Your Ref: OWPC7221
Our Ref: EP/120/15/HH 11-09-2015
Please ask for:
Mrs A Gardner

Remodelling & extensions
Hascombe 33 Tamarisk Way East Preston

Thank you for your internet representation made on 21st October 2015 which has been recorded as '**an objection**' with the comments as follows:

client	Jason Richardson
job	Hascombe Tamarisk Way East Preston West Sussex
dwg no.	1043.06e
title	Proposed Ground & First Floor Plans
drawn by	SM
checked by	KT
scale	1:100 @ A1
date	05.08.15

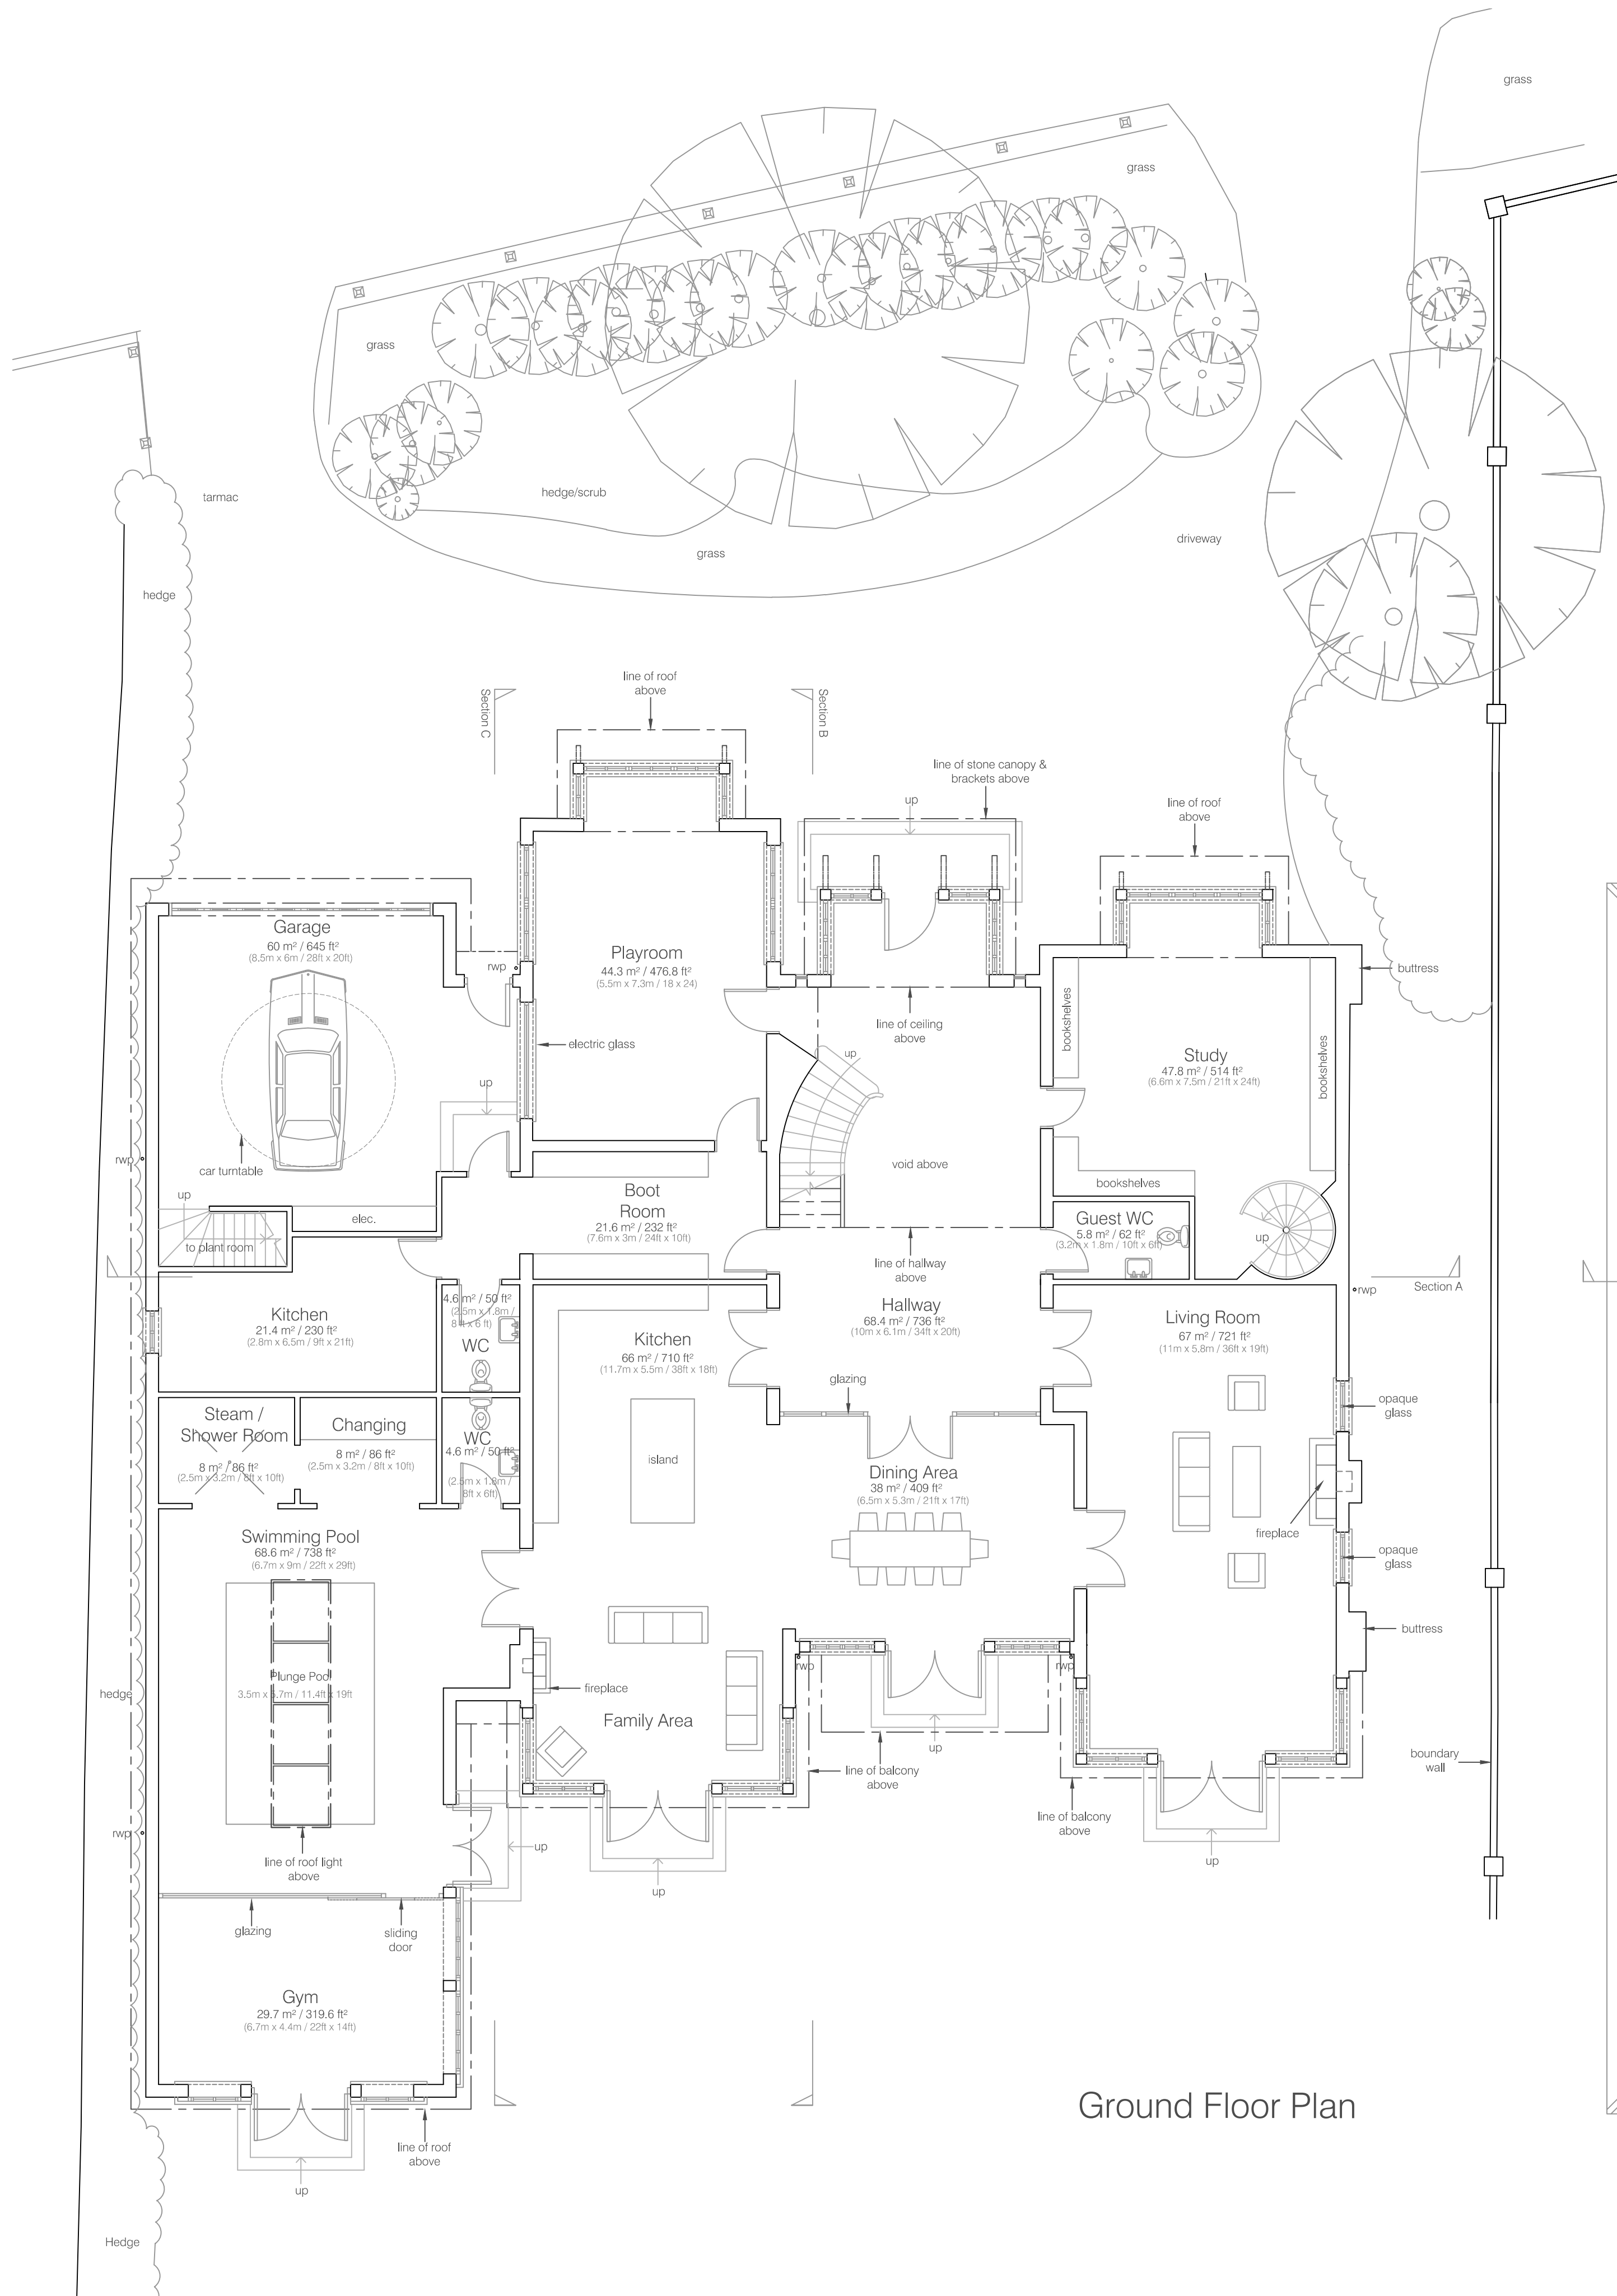
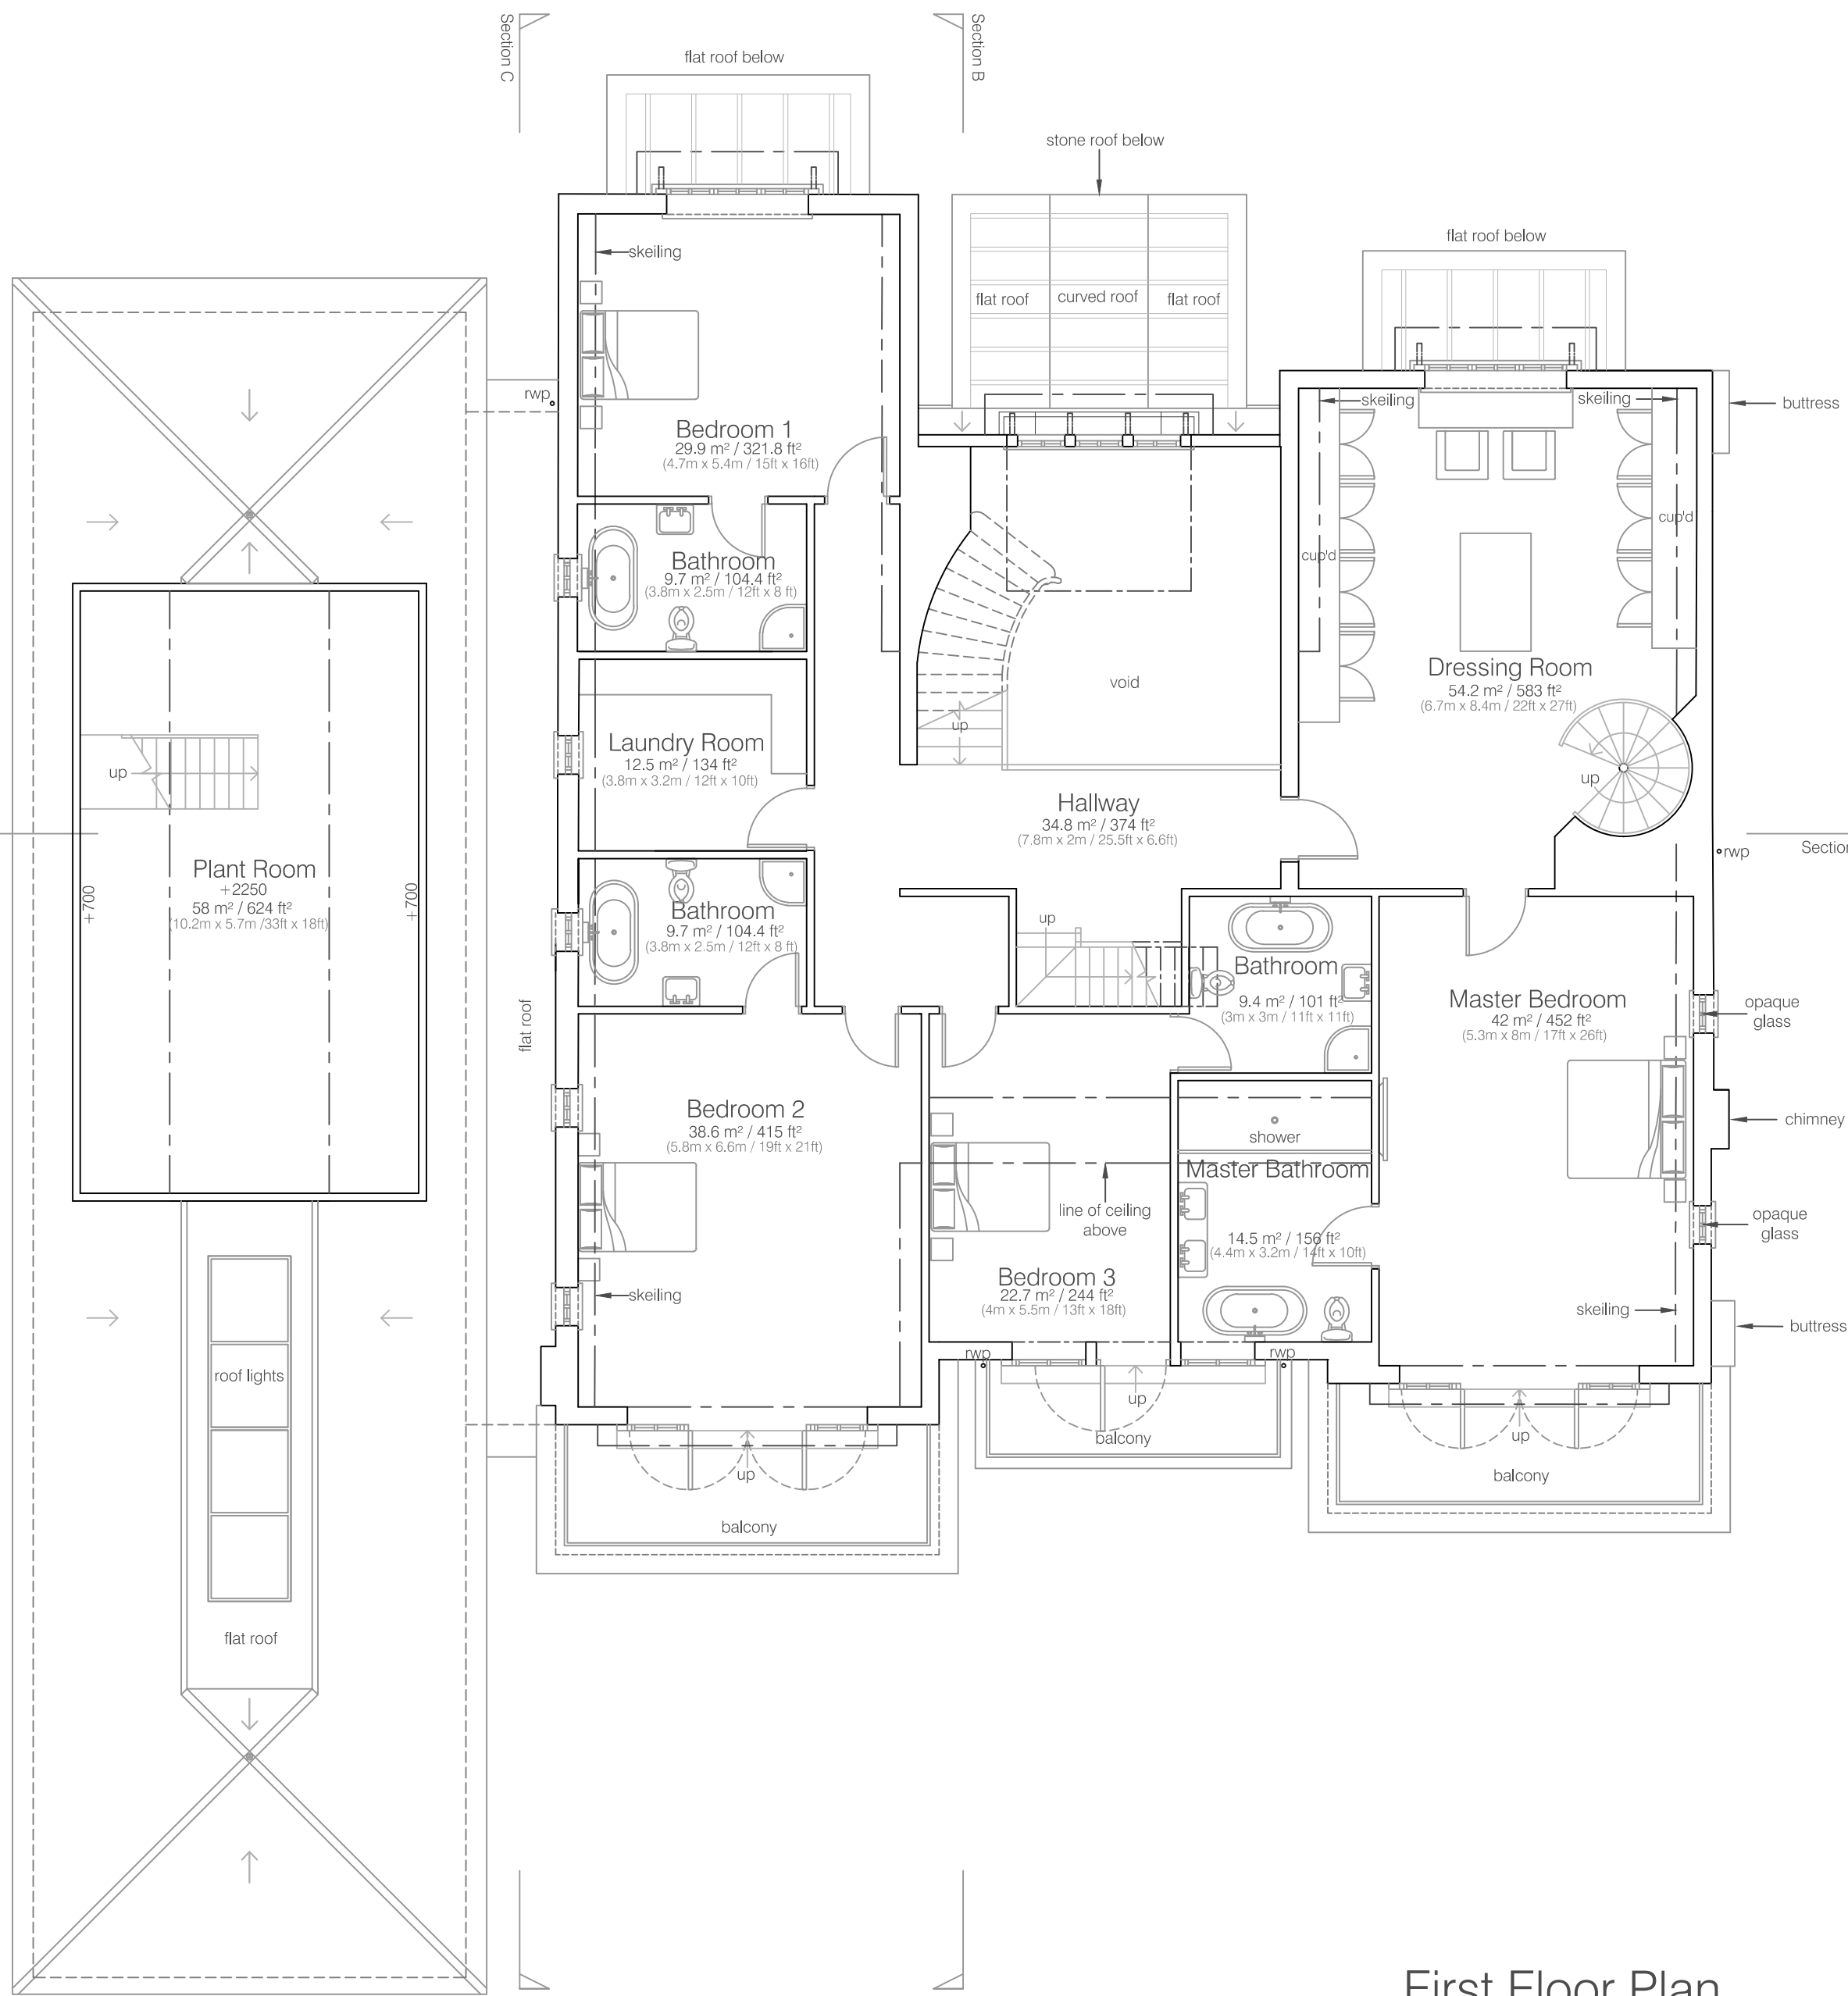
I think the increase in footprint , which is substantial enough already, makes the proposed house overbearing in relation to the others- particularly to its immediate neighbour to the East, Flagstones.Why not demolish the existing house, and rebuild to scale. I acknowledge that the interior accommodation is dated, and compromised for modern living, but if starting from scratch could achieve everything needed to make a magnificent home without over being excessive. The proposed detail to North and south Elevations are pleasing., and welcome.

I do especially object, however, to what I can only describe as a " municipal "style swimming pool/Leisure Complex along the Westerly Boundary..
